RE: 133 YORK STREET

Attached are revised plans for the project. The changes include:

EROSION CONTROL AND LANDSCAPE PLAN

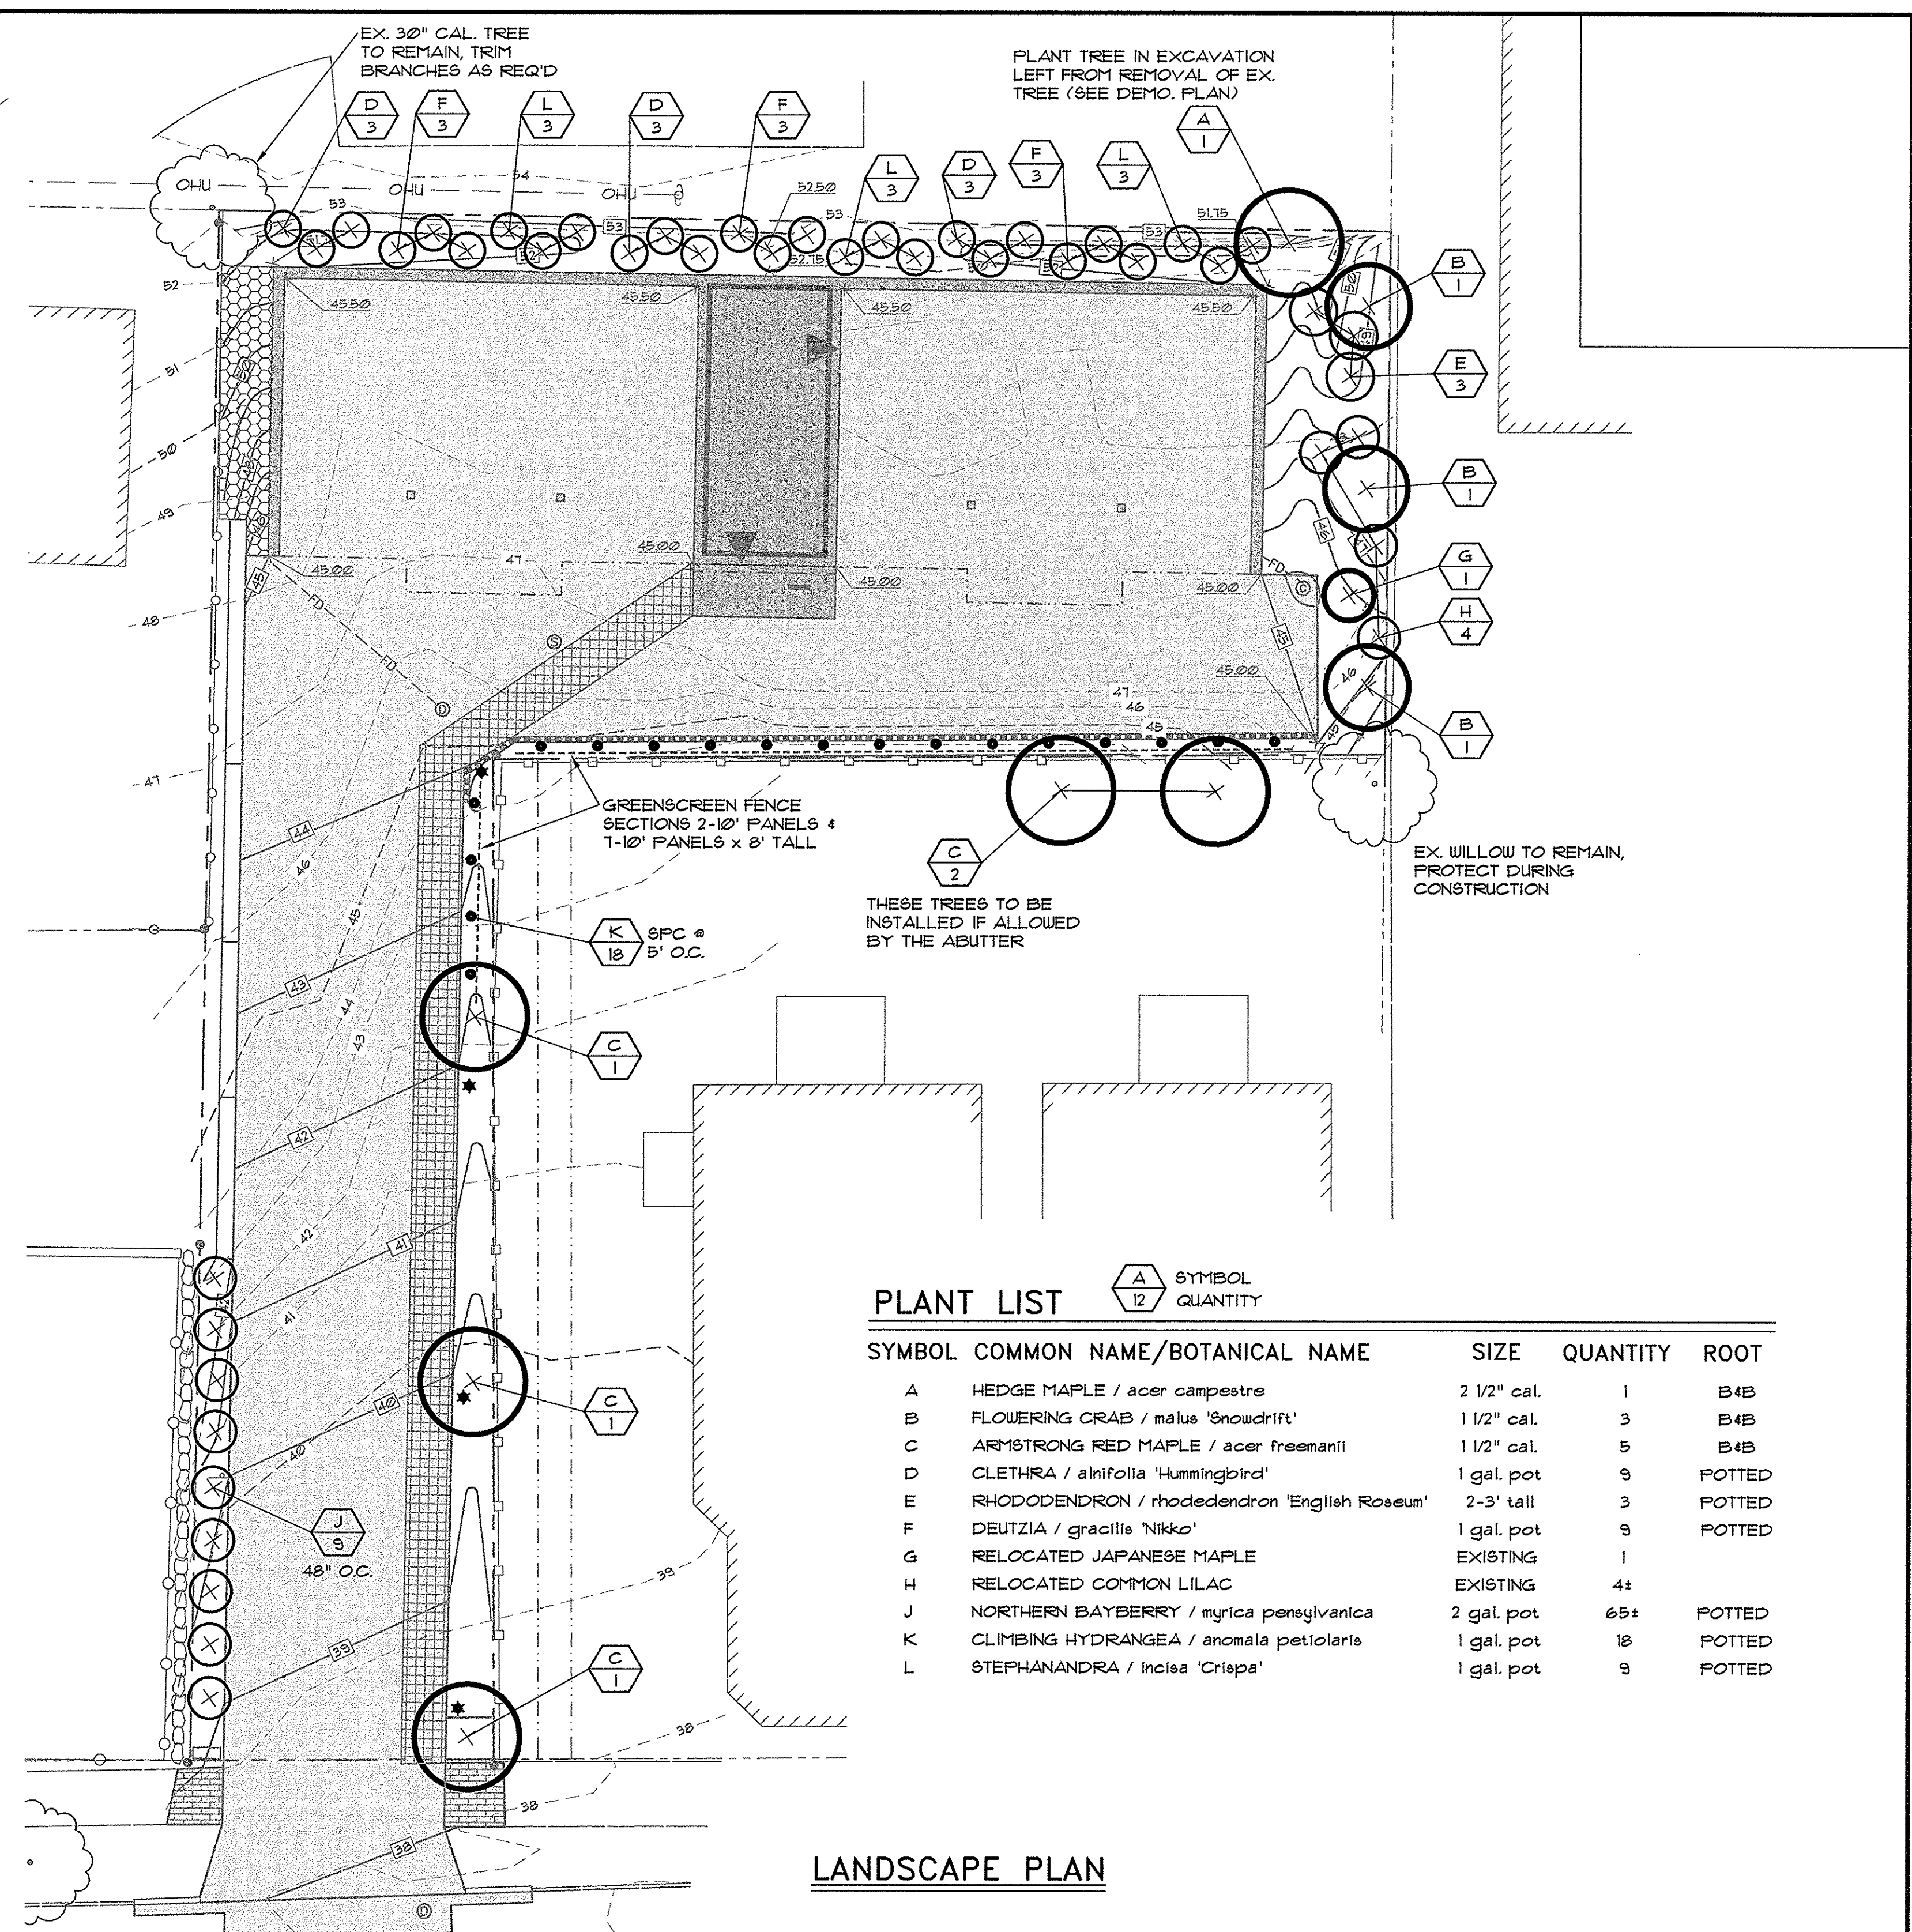
1. Revised driveway entrance to remove brick sidewalk and cobblestones.
2. Revised electrical and gas service to come from York Street.
3. Revised landscape plan per Jeff Tarling's email.
4. Have labeled 20' fire land and no parking.
5. Provide revised drainage calculation and maintenance requirements for the stormwater system.
6. We have provided a narrative on the construction plan.
7. Attached are revised parking templates. As you can see we can get very large vehicles, 19' in length, into and out of the spaces. We expect much smaller vehicles will use the spaces.
8. We have revised the survey to add the coordinates to the plan.
